**KIRKLEES METROPOLITAN COUNCIL
INVESTMENT & REGENERATION SERVICE**

DELEGATED DECISION TO DETERMINE PLANNING APPLICATIONS

Reference No:	2023/60/91413/W
Site Address:	adj, 25, Richmond Avenue, Fartown, Huddersfield, HD2 2QH
Description:	Outline application for erection of residential development
Recommending Officer:	Tom Hunt

DECISION - REFUSED

3. Proposed Site Layout

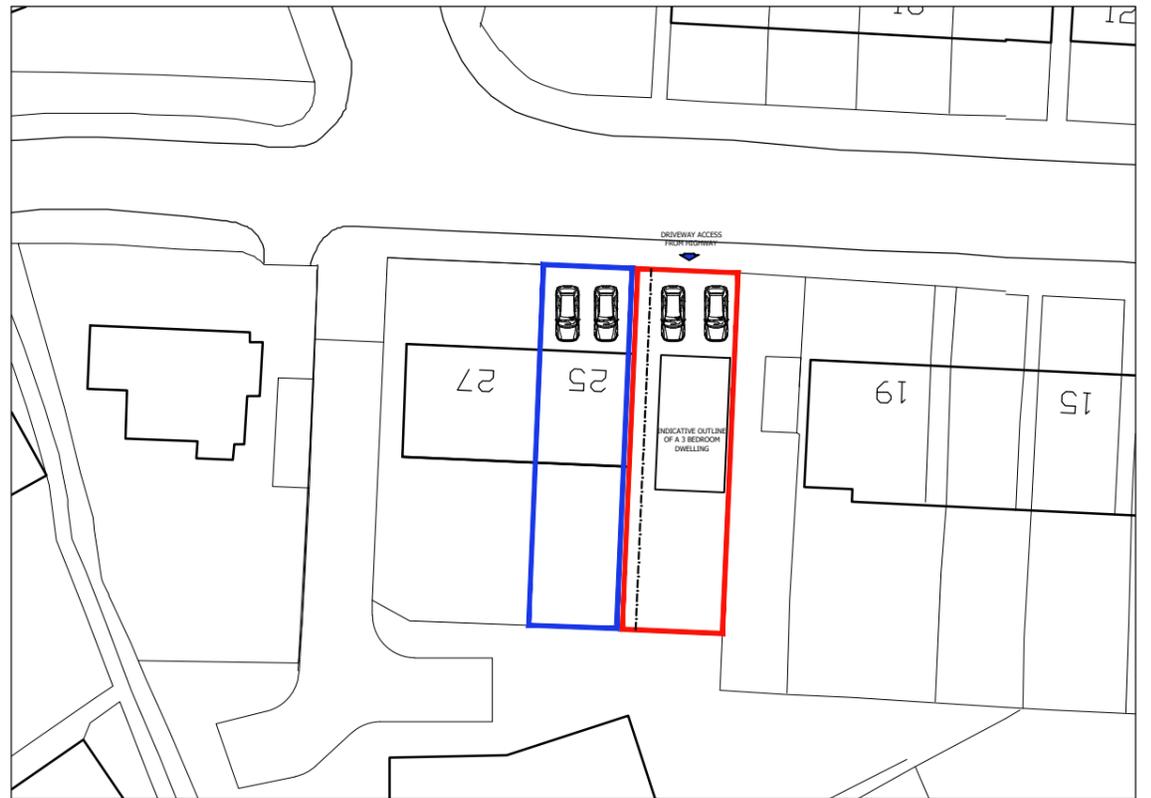
The indicative layout shows the dwelling having a footprint of ~45.6sqm, it would have its primary elevation set back 6m from the pavement, northwest elevation set back 0.85m from shared boundary with no. 25 and southeast elevation closely set to the boundary with no. 19 with an adequately proportionate garden area to the south. Whilst layout has not been applied for, the indicative details are considered to represent the only realistic layout of a dwelling on the site and would follow established building lines to the front which would aid in a coherent development. In addition it would have a rear elevation in line with the residential terraced properties to the east (but not the western properties) in general compliance with Principle 5 of the Housebuilders Design Guide SPD.

Viewed against the grain of the wider locality, its indicated footprint would appear visually narrower than existing terraced properties and would appear as a detached property in between semi-detached and terraced properties. This would fail to provide a positive and coherent identity appearing contrary to Principle 2 of the SPD.

In addition to this, new builds should have a minimum of two metres distance to flank boundaries (Principle 6). The detached and semi-detached properties on Richmond Avenue sit on relatively wide plots and while a number have built development quite close to their boundaries, it is mainly in the form of a single storey garage with open space above, visually smaller two-storey side extensions and space afforded by driveways, therefore maintaining some sense of space around the properties. While there are clearly no gaps between the individual dwellings within the nearby terraces, there are open spaces and reasonably sized spaces between the terraces and the other properties on Richmond Avenue. In neither case, do the buildings appear cramped or squeezed into their surroundings. The plot here is very narrow (~6.8m) which would not enable a dwelling to be sited without appearing contrived and visually cramped on the restricted site, if the standards of the adopted design code were to be adhered to. The proposed development of the site, in principle, would therefore have a visually incongruous appearance to the locality and be out of character to the streetscene contrary to Principle 2 and 6 of the SPD.

Parking within the immediate area is shown to be to the front of properties and within driveways. Whilst it is observed that the front amenity spaces of nos 19 and 25 are hard surfaced, they are not used exclusively for vehicle parking with patio use providing a sense of openness. To have an additional 3-bedroom property with parking to the front for two vehicles and in addition, no. 25 having the same parking arrangement would cumulatively lead to an unattractive intensification of parking use and would appear overly dominated by car parking and hardsurface contrary to Principle 12 of the Housebuilders Design Guide SPD. Although this arrangement is ‘indicative’, if the site were to be developed, this would be the only way to achieve compensatory parking for no. 25 or to provide off street parking for a new dwelling here, given the limited width of the plot.
